Re: Barnside, Hook Lane Aldingbourne, West Sussex
Drainage Condition AL/28/20/DOC

We have reviewed the Drainage Engineer comments forwarded on 1st May 2020 from Arun DC.

DRAINAGE MANUAL

Scale: 1:250	Paper Size: A1	Date: JUNE 2019	Drawn By: PJM	Checked By: CH
Project No.: AAL156	Drawing No.: 501	Revision: P4

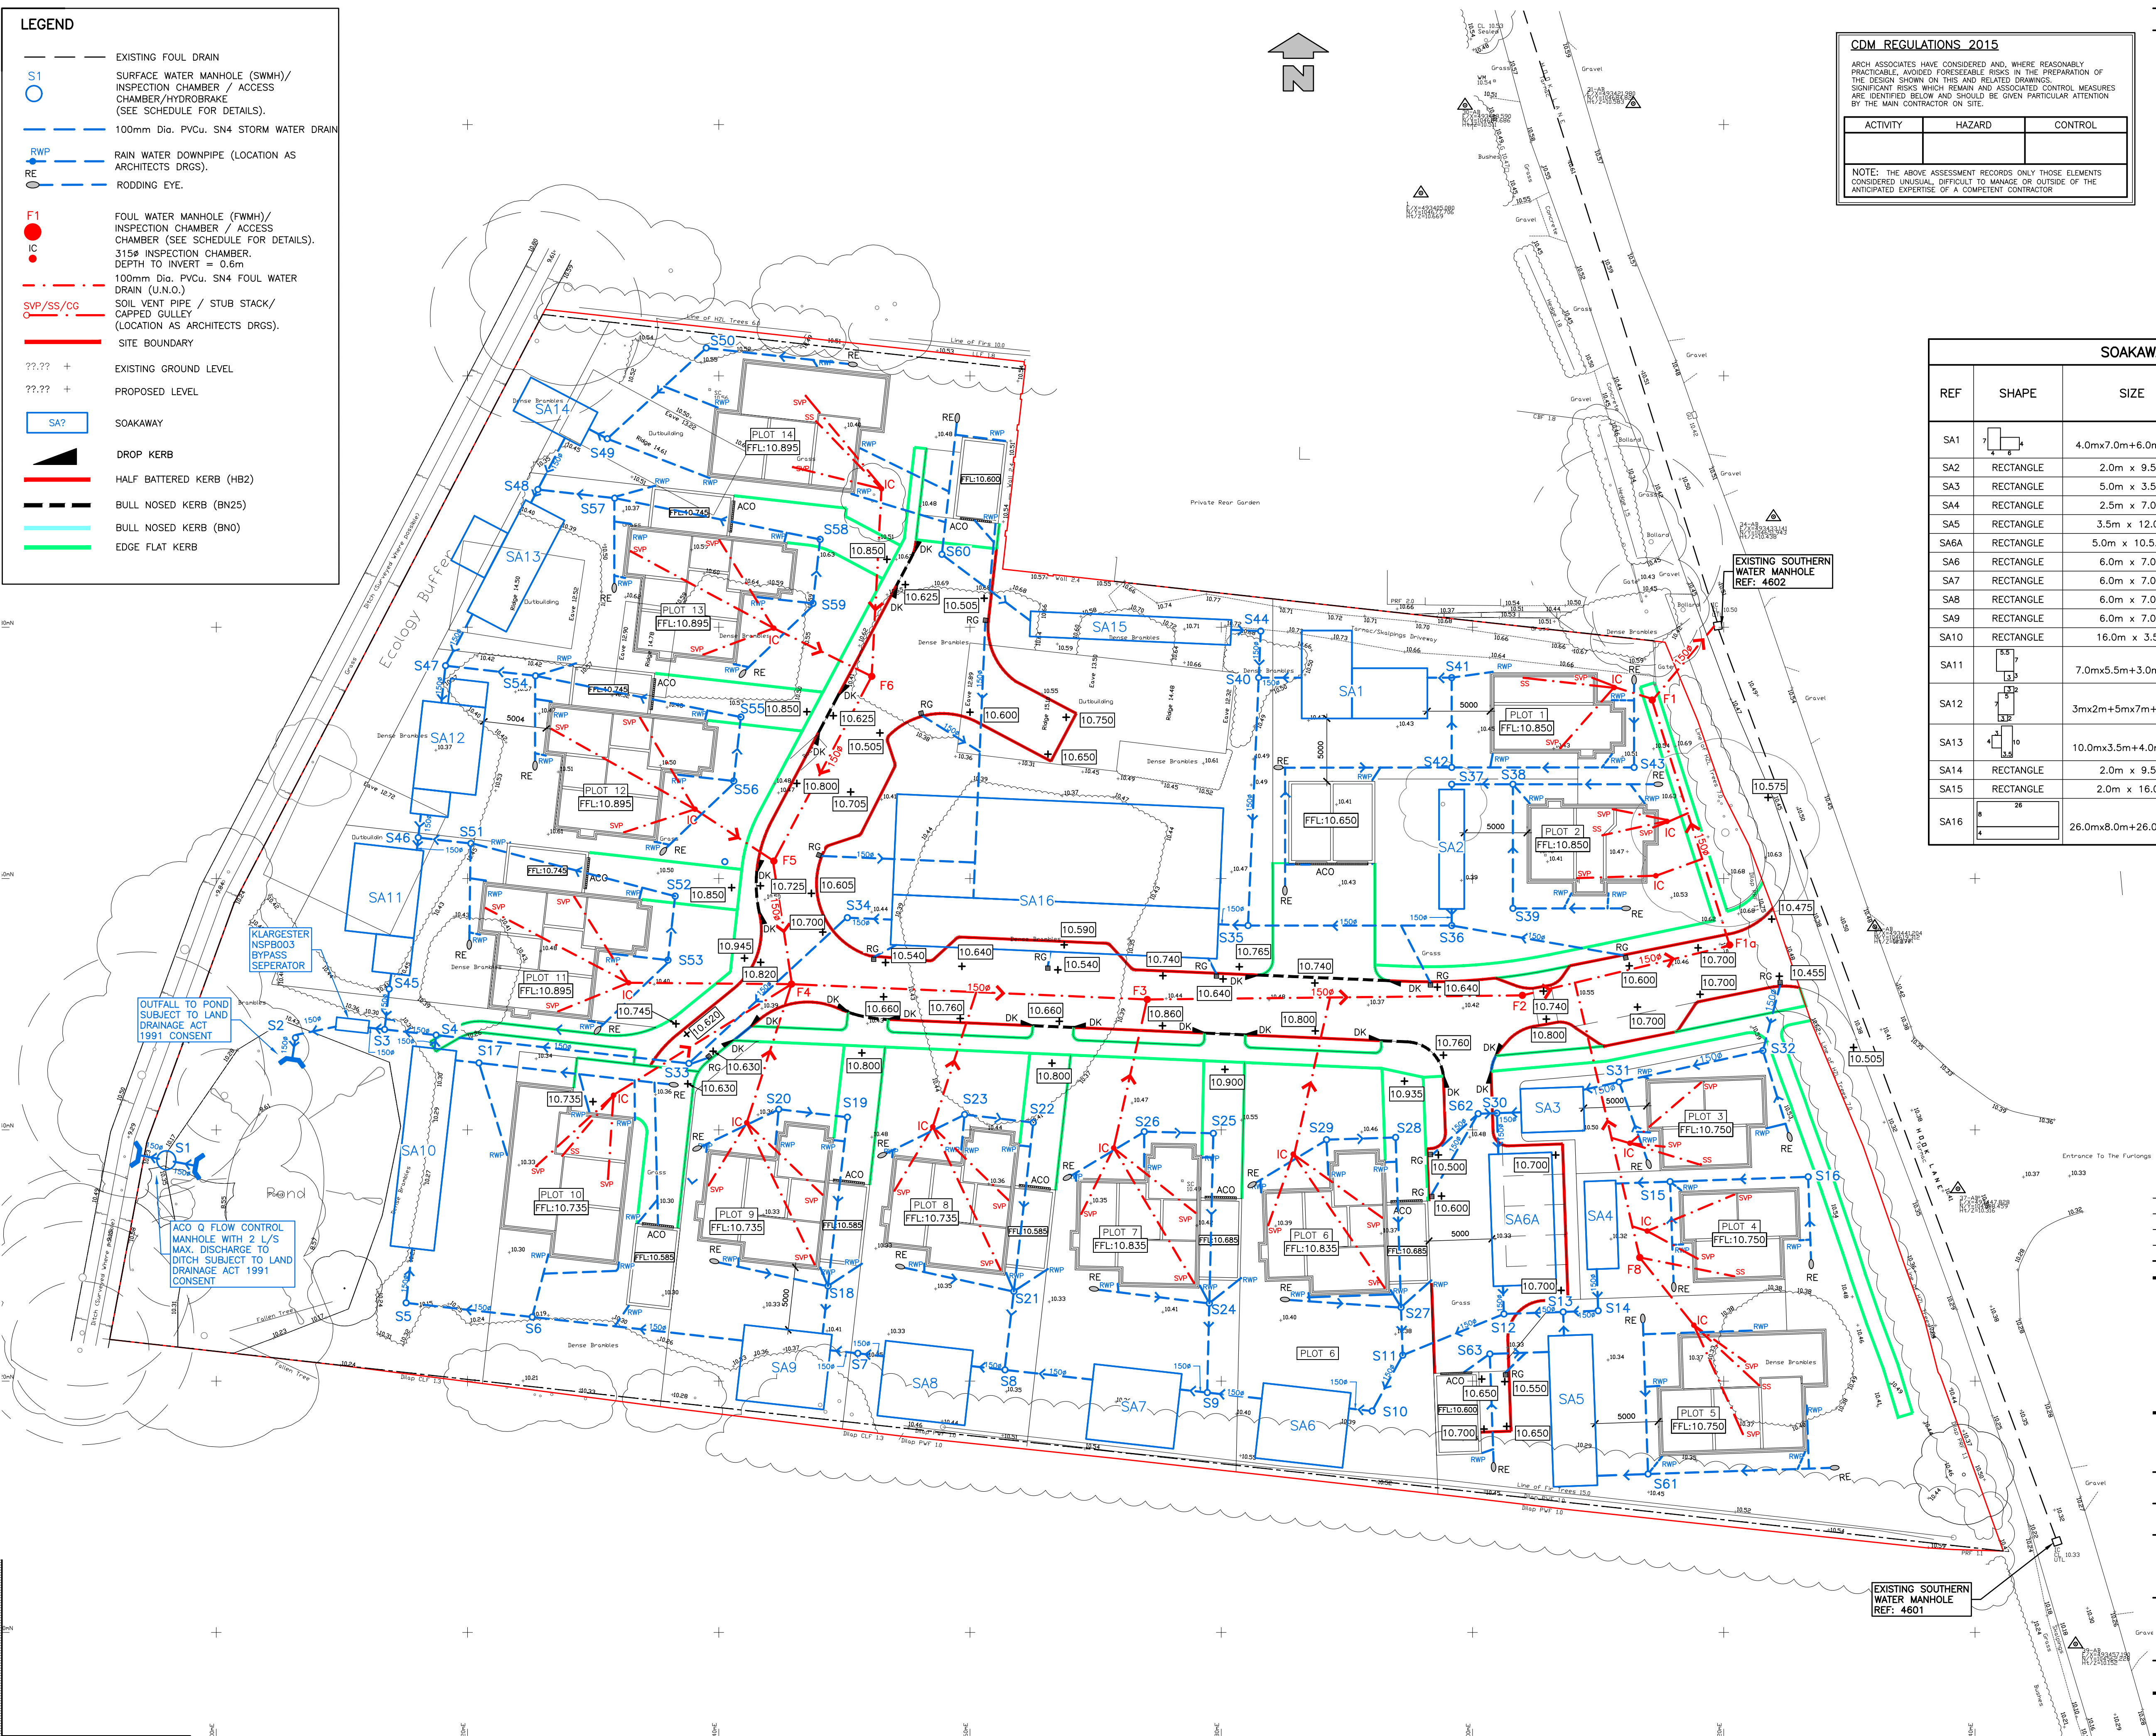
We have drawn the relevant information into the attached drainage manual for the site including ADC standard outfall details. The final Arch Associates Drainage layout may need to be updated to make reference to the agreed ADC outfall detail from the OWC application but this is a matter of procedure.

ELEVATION OF HEADWALL OUTLET INTO & OUT OF POND (WITH SUMP)
(1:25)

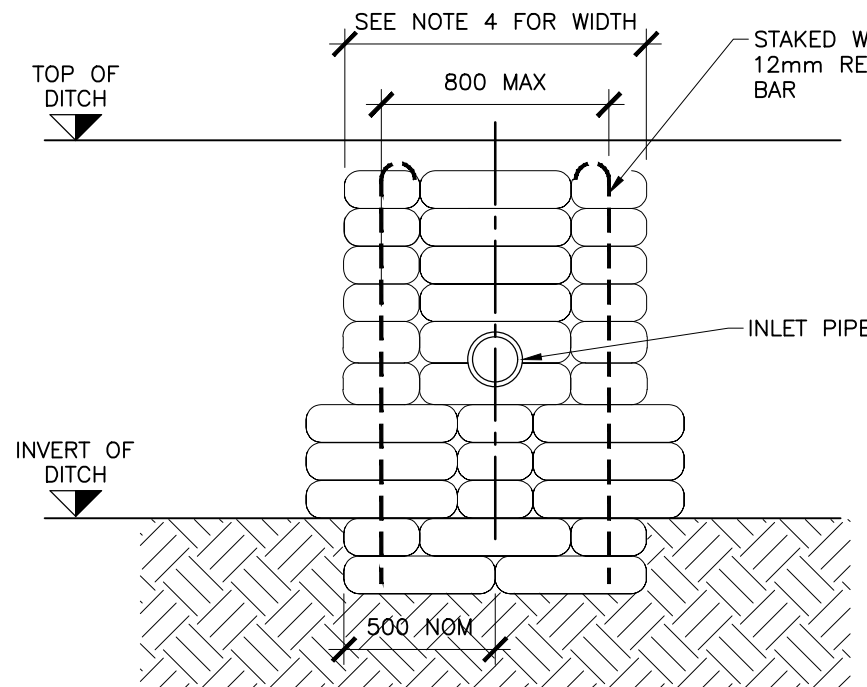
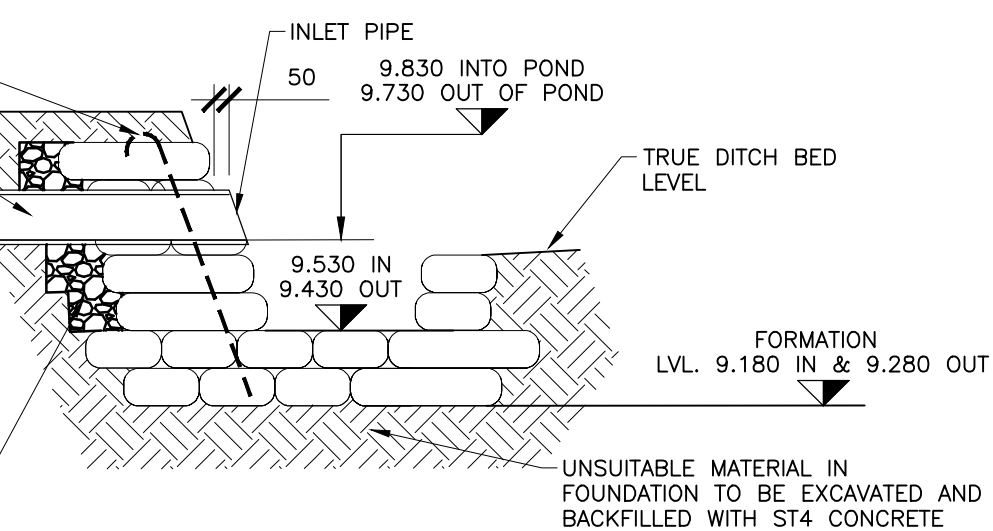
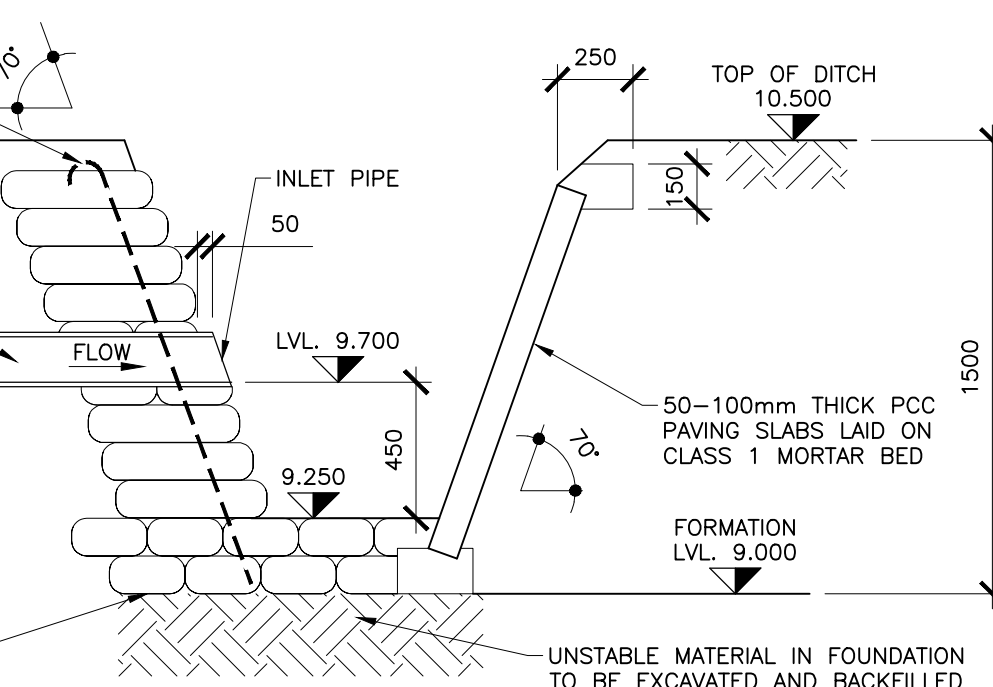
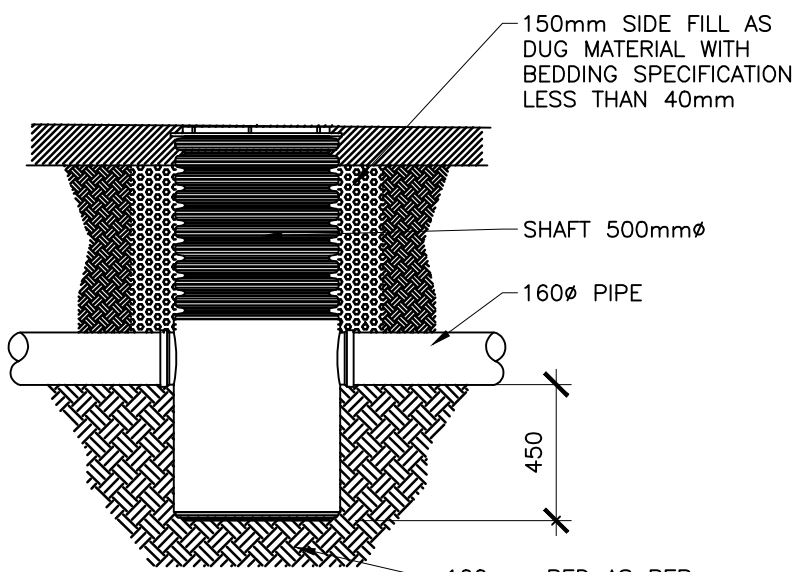
An Ordinary Watercourse Consent (OWC) application will need to be made to ADC for the outfall to the pond and to the watercourse. To be clear there is no existing outfall from the pond as can be seen from the site topographic survey and we also understand Laura Gibbons confirmed this during a site visit last year.

The petrol interceptor comprises a Klargestor NSPB003 bypass interceptor. The EMC will arrange for maintenance of this in accordance with the manufacturer's recommendations. Residents shall communicate any concerns with this apparatus to the Estate Management Company for their action. The outfall to the pond is of concrete bagwork construction in accordance with ADC drawing 80000102 (copy attached)

MANHOLE WITH HYDRO-BRAKE
(1:25@A1)

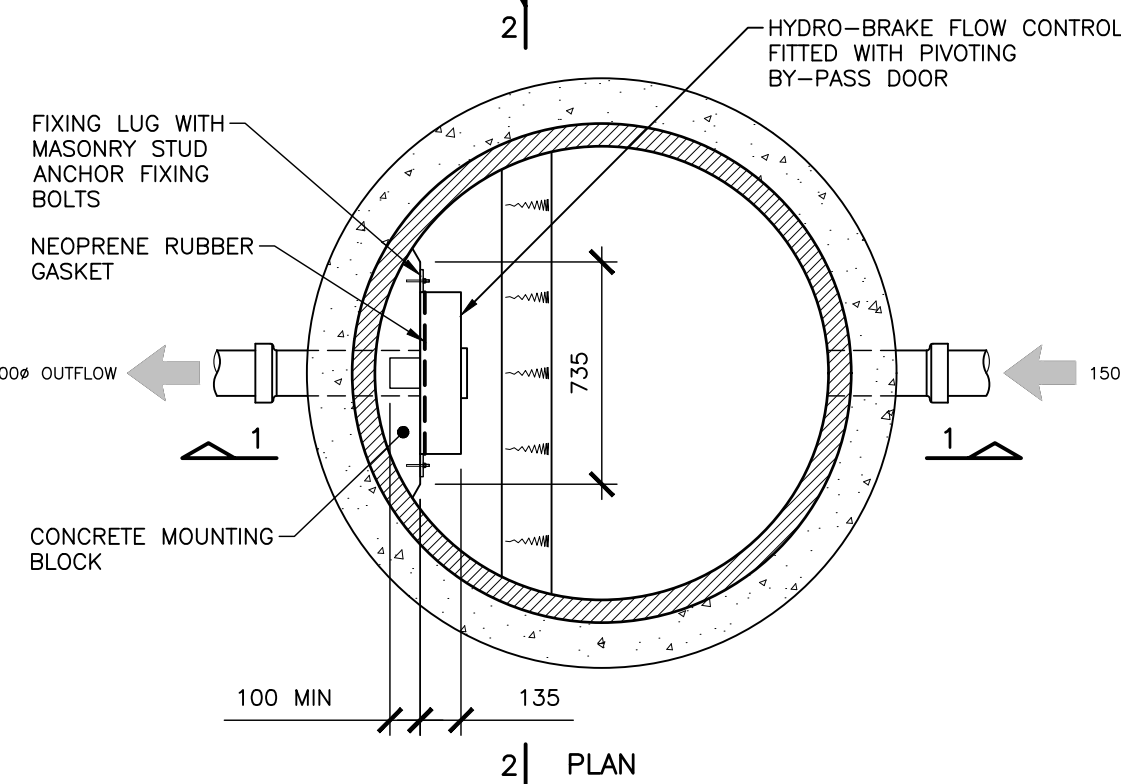
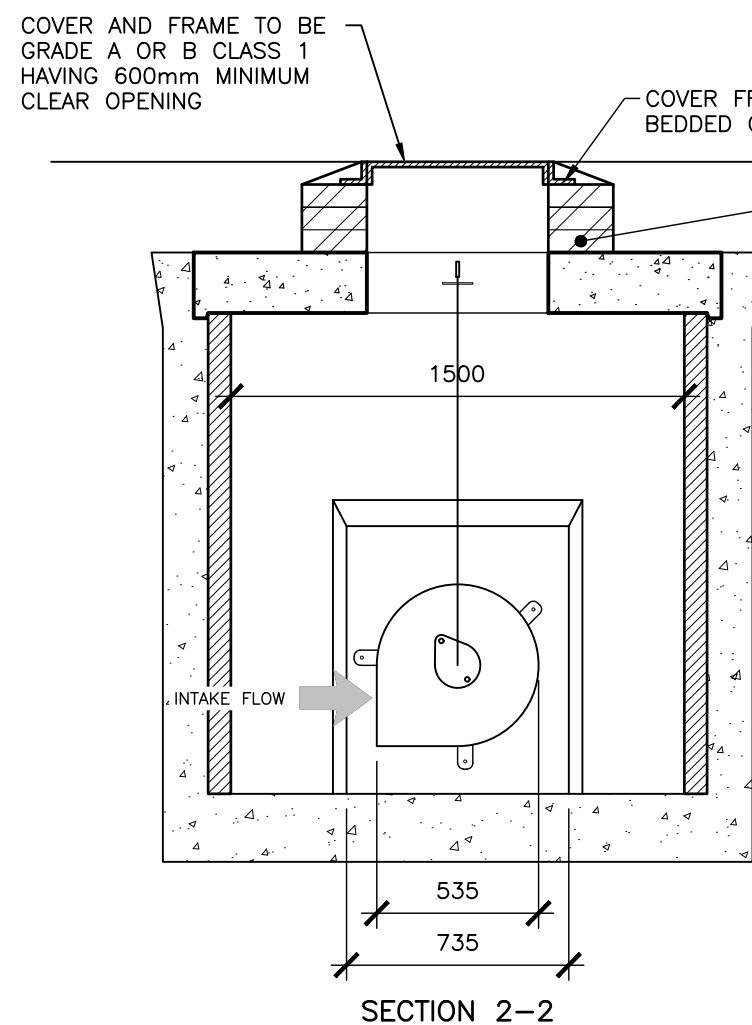
In summary the scheme provides for full infiltration to at least 10%AEP +40%CC before any pond storage would be mobilised. The pond then provides enough additional storage for the 1%AEP +40%CC excess and regulates this to 2 l/sec discharge. The half drain time for 1%AEP +40% CC is 32 hours and 10%AEP+40%CC half drain occurs within 24 hours.

To limit the discharge flow rate out into the watercourse a 'ACO Q flow control' is fitted with a flow control device limiting flow to 2 l/sec. It is essential that this chamber is left covered and that debris is not permitted to fall into the chamber. The petrol interceptor and sediment catch pits and gulley sumps are present to reduce the likelihood of blockage from upstream within the system and the flap valve to the outfall will similarly reduce the risk of blockage from downstream. These should be inspected at least annually and after significant rainfall events. If detritus is present this should be removed. The EMC will arrange for maintenance of this in accordance with the manufacturer's recommendations. Residents shall communicate any concerns with this apparatus to the Estate Management Company for their action. The outfall to the watercourse pond is of concrete bagwork construction in accordance with ADC drawing 80000102 (copy attached)
